Rezoning Transportation Analysis

Petition Number: 2022-216

Date	Description
05-24-2023	First Review (JP)
11-27-2023	Second Review (TP)

November 13, 2023

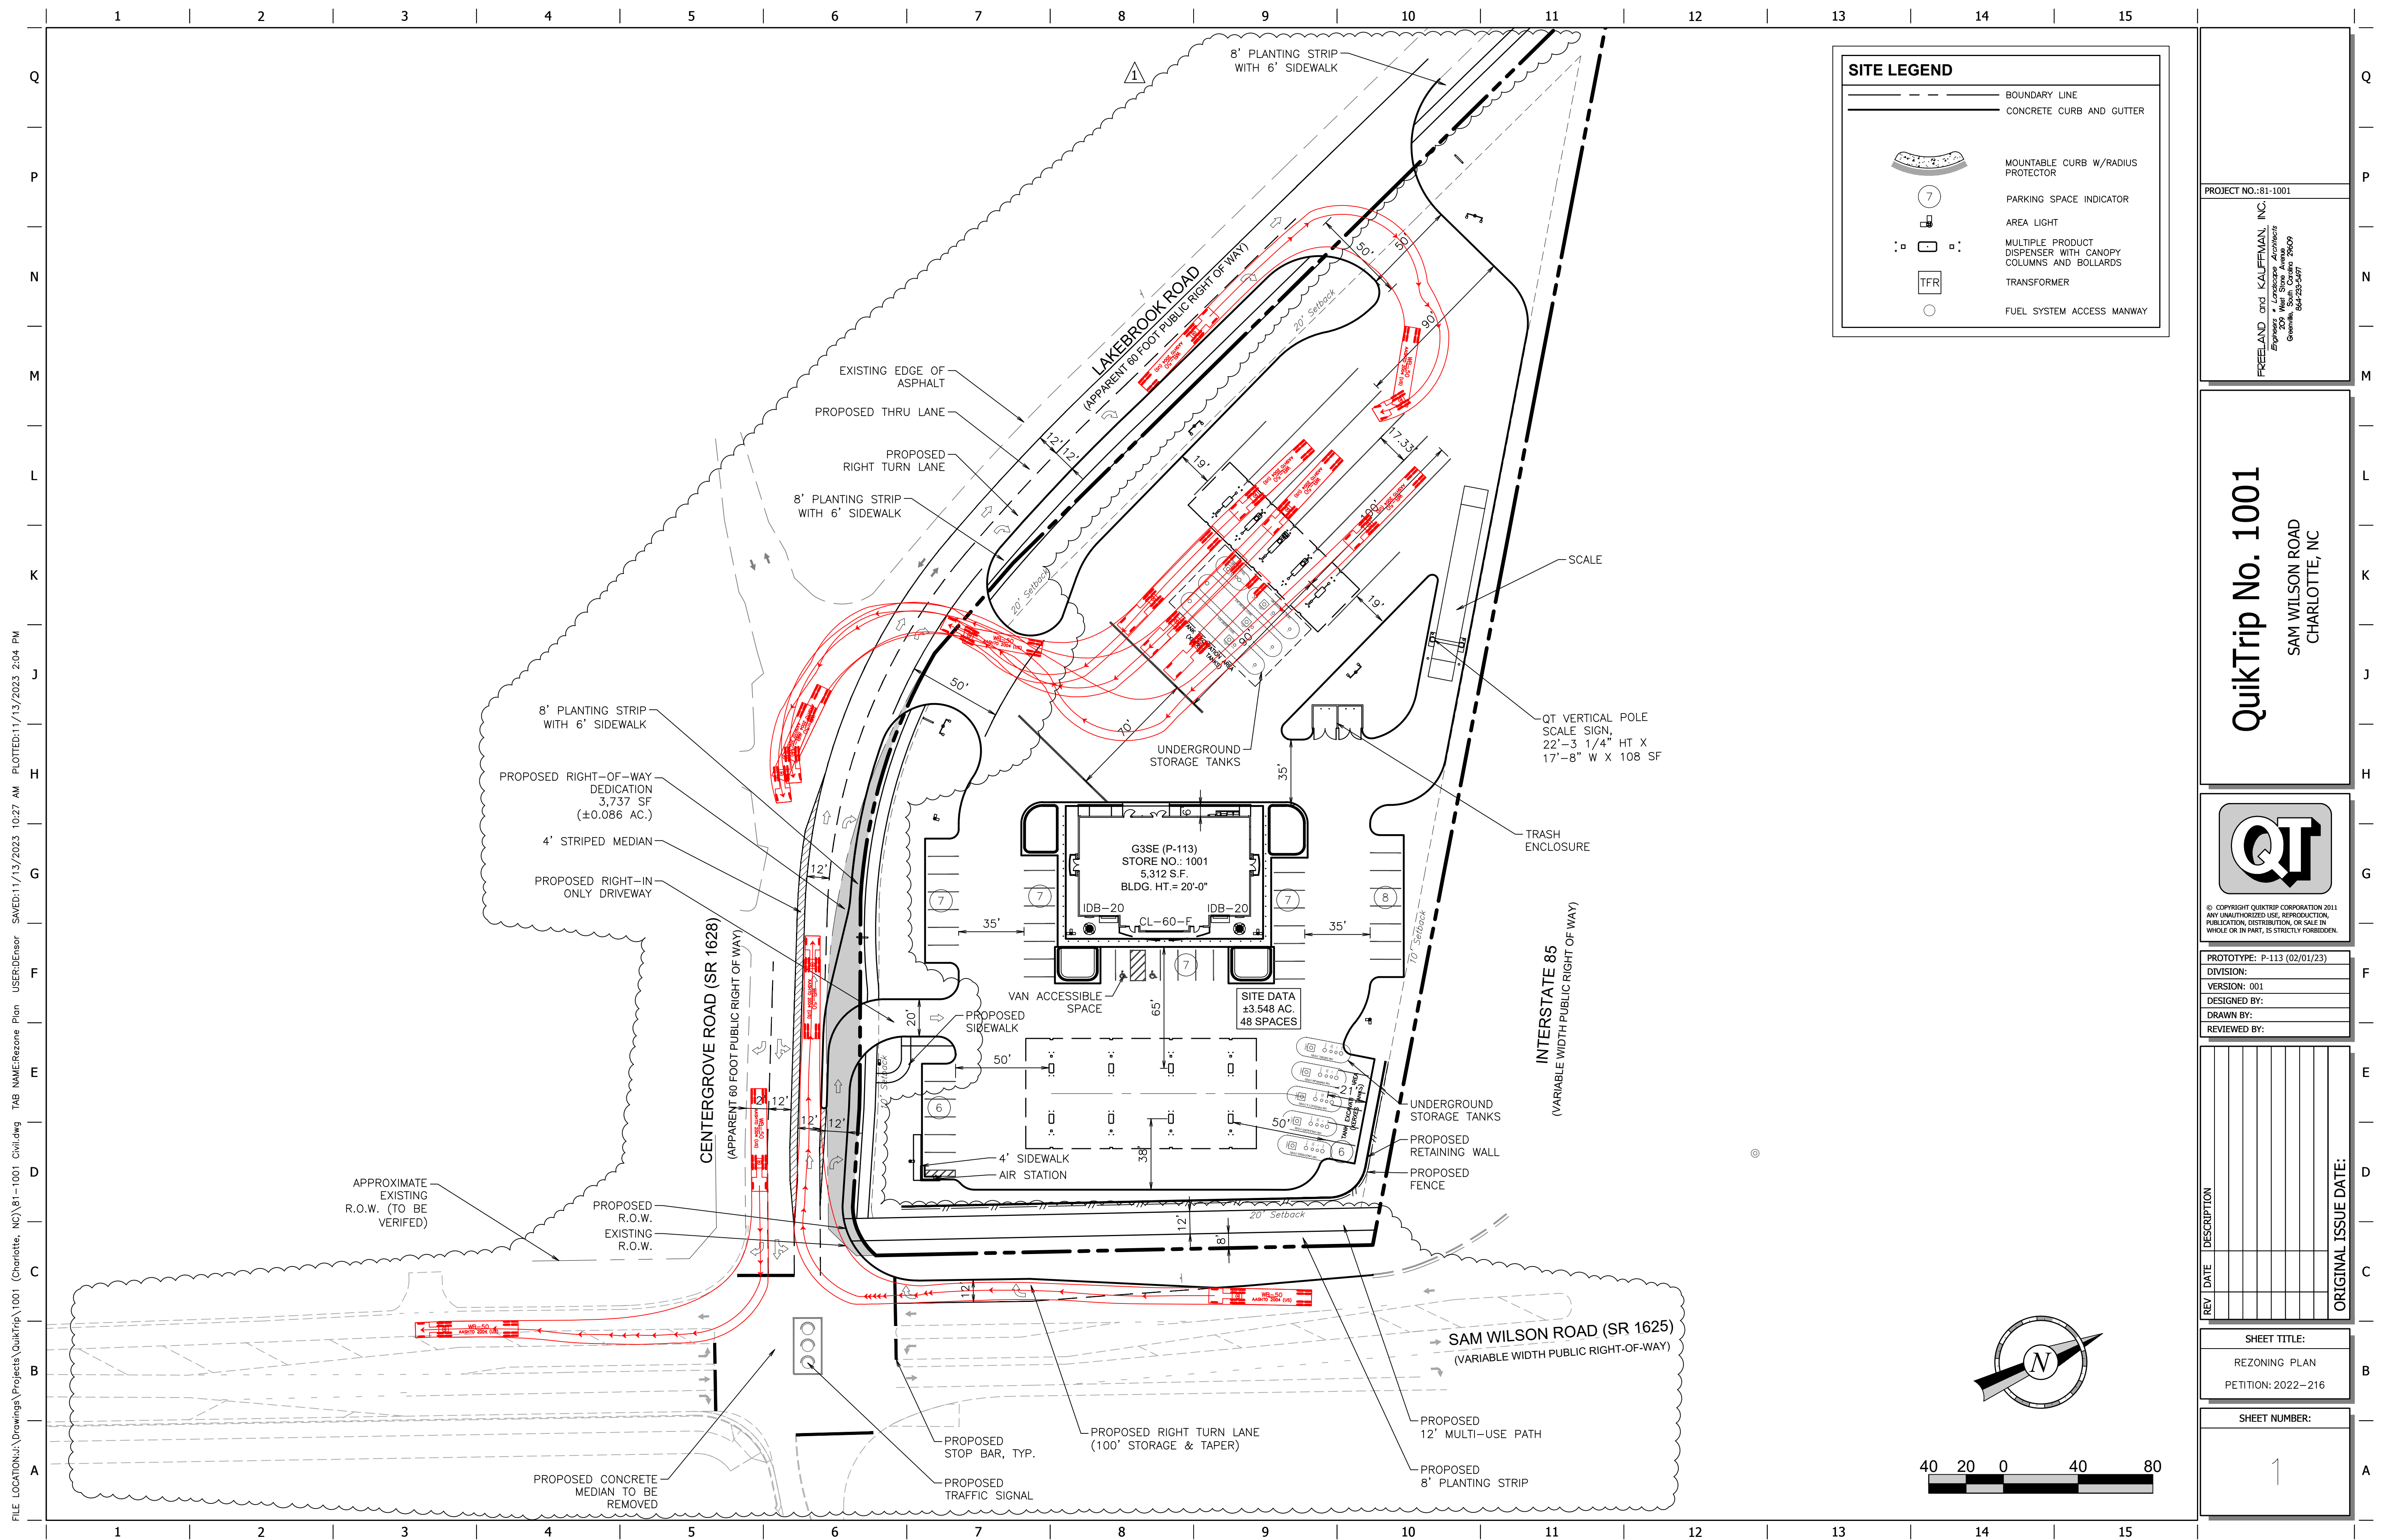
- Sam Wilson Road:** Location of curb and gutter to be moved to 30 feet from roadway centerline to accommodate the Charlotte Streets Map with a roadway typical section of a 4+ avenue with a 12-foot multi-use path.

NOTE: Additional distance from center line to back of curb may be required in locations where a median and turn lanes are required. Final curblines locations to be reviewed by CDOT once TIS is approved.

Label and dimension the curb and gutter from the centerline for each road on the site plan.

Clarifying comment 11.27.2023: Label and dimension curb and gutter from roadway centerline on Sam Wilson.

4. Revise site plan and conditional note(s) to commit to dedicate 35 feet of right-of-way from the road centerline on Sam Wilson Road. The site plan shall label and dimension the right-of-way from the road centerline.

Clarifying comment 11.27.2023: Label and dimension right-of-way from roadway centerline on Sam Wilson.

11. Revise site plan and conditional note(s) to construct 8-foot planting strips and 6-foot sidewalks on Centergrove Lane and Lakebrook Road and a 12-foot multi-use path on Sam Wilson Road. The site plan shall label and dimension both items from the back of curb and gutter or edge of pavement. Add conditional note The entire facility must be outside of the right of way and within a public access easement. Add conditional note committing to construction and maintenance of the 6-foot sidewalk on Centergrove Lane and the 12-foot multi-use path on Sam Wilson Road.

Clarifying comment 11.27.2023: Add conditional committing to maintenance of 6-foot sidewalk on Centergrove Lane.
